From: Planning
Subject: FW: planning application 3/2020/0507p

From: Gaskell, Gemma <Gemma.Gaskell@uuplc.co.uk>
Sent: 04 November 2020 17:26
To: Adam Birkett <Adam.Birkett@ribblevalley.gov.uk>
Cc: Churchman, Tracy <Tracy.Churchman@uuplc.co.uk>
Subject: RE: planning application 3/2020/0507p

I have reviewed the earlier planning approval for the site together with the response of United Utilities at that time.

Land south of Lower Road, Longridge – Indicative layout

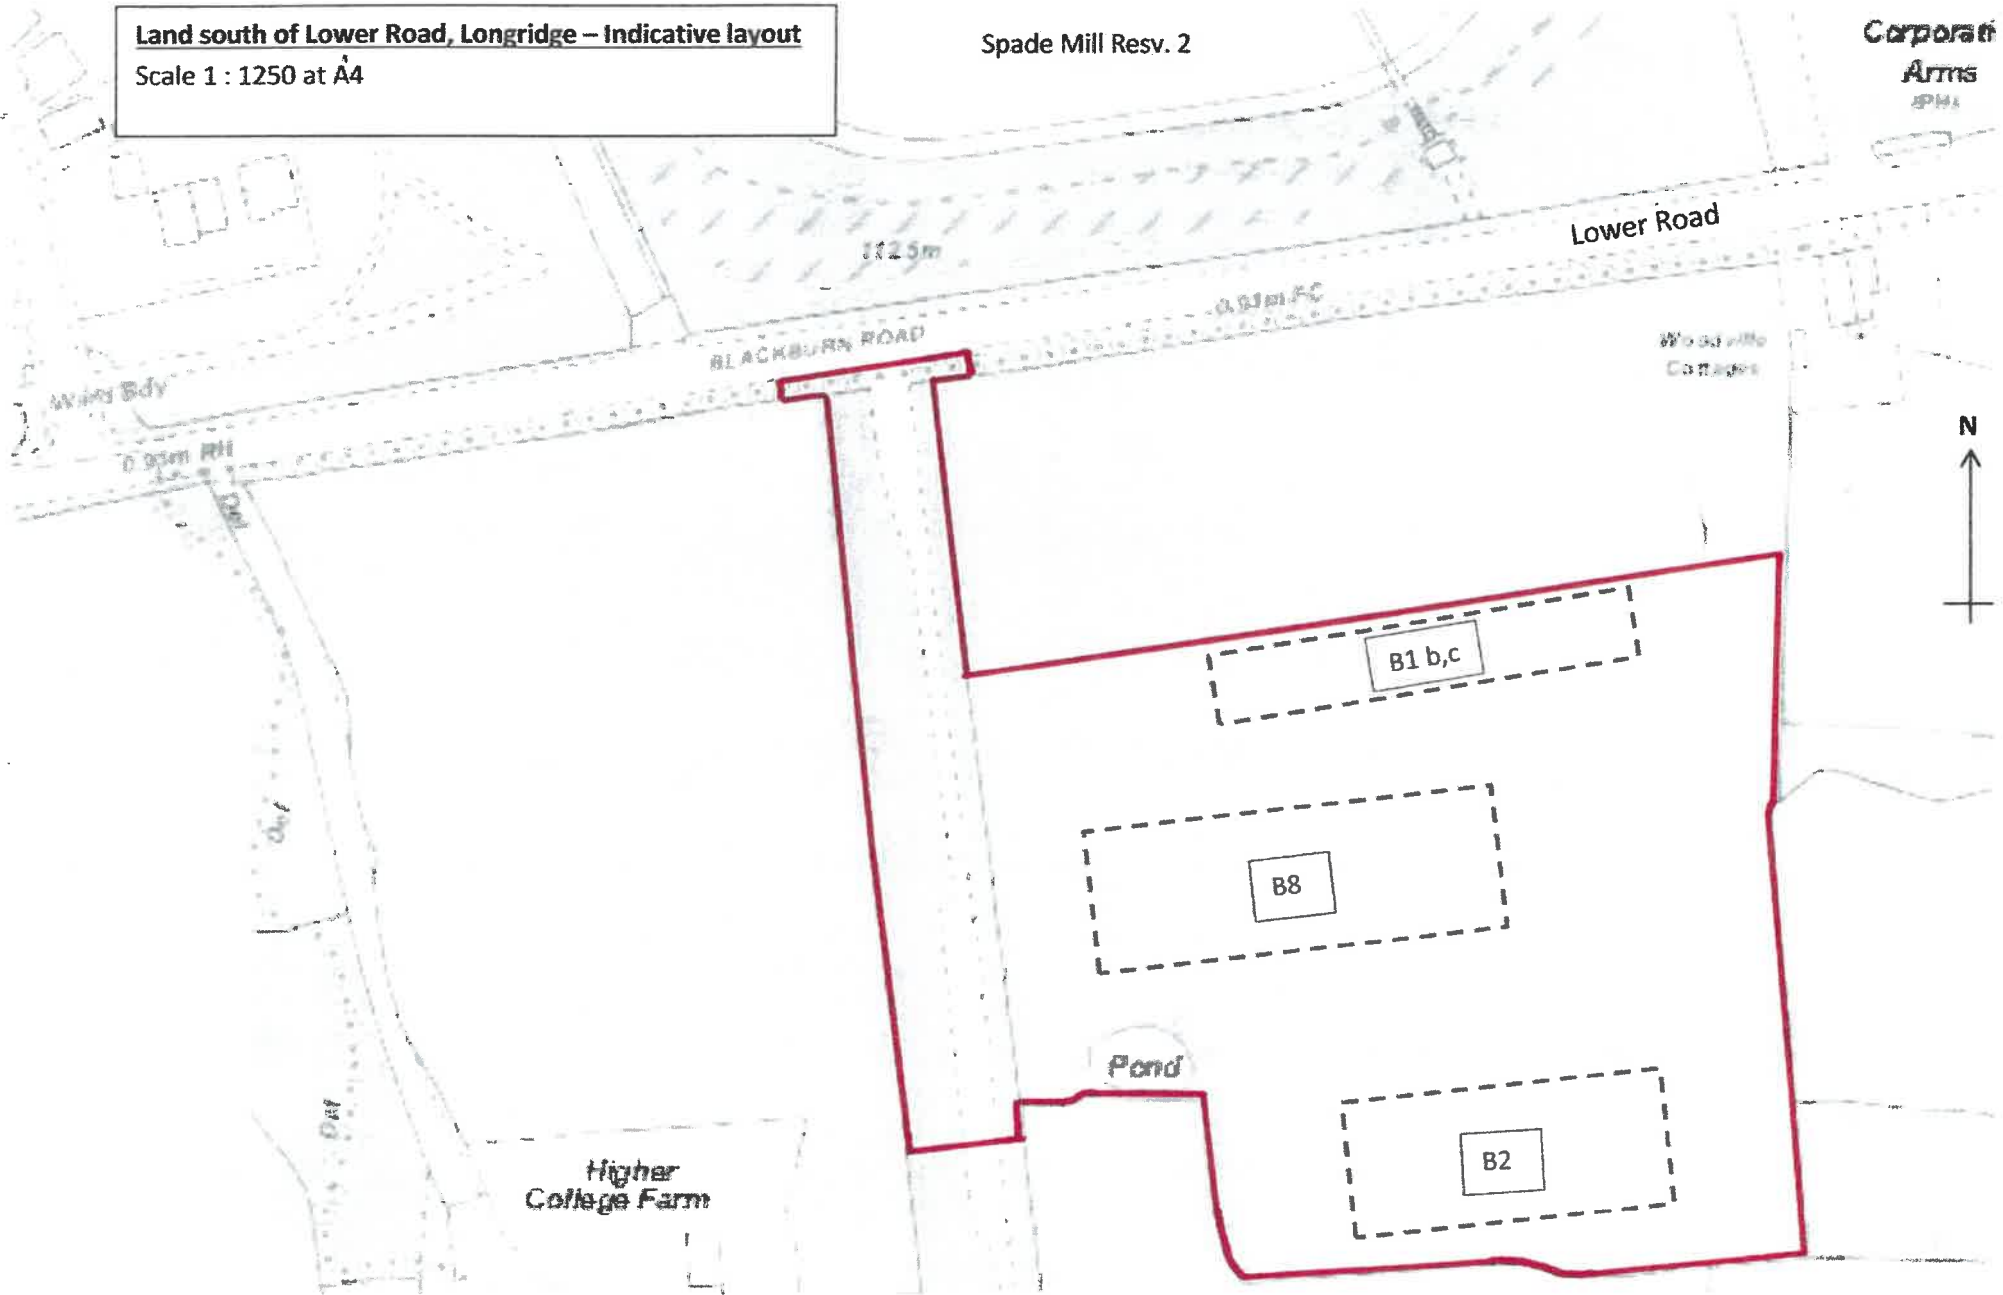
However, we must advise that the indicative layout submitted with the current planning application (reference 3/2020/0507) shows proposed business units close to or directly on top of the existing large diameter raw water main for which there is a formal easement in place for (UU Ref R376 dated the 14/09/1953). This will need further investigation prior to the drawing up of a detailed site layout for approval, as under no circumstances should anything be planted, or erected or any materials stored over the easements, nor should anything occur that would affect the integrity of the pipe of UU's right to 24 hour access. The level of cover to the water mains and sewers must not be compromised either during or after construction.

The required stand-off distance from the main (as detailed in the easement or UU's Standard Conditions Document) should be taken into account in the final site layout, or a diversion will be necessary, which will be at the applicant's expense.

No development shall take place until a Construction Risk Assessment Method Statement (RAMS) for construction of the proposed development, is submitted to and approved by the Local Planning Authority. The statement shall outline the potential impacts from all construction activities on infrastructure that crosses the site and identify mitigation measures to protect and prevent any damage to this infrastructure. The development shall be undertaken in accordance with the approved RAMS.

It is the applicant's responsibility to demonstrate the exact relationship between any United Utilities' assets and the proposed development. The applicant can discuss any of the above with our NAV & Asset Protection Engineer, **Sara Livesey** at DeveloperServicesWater@uuplc.co.uk who will provide advice on identifying the exact location of the water main and additional protection measures that will be required.
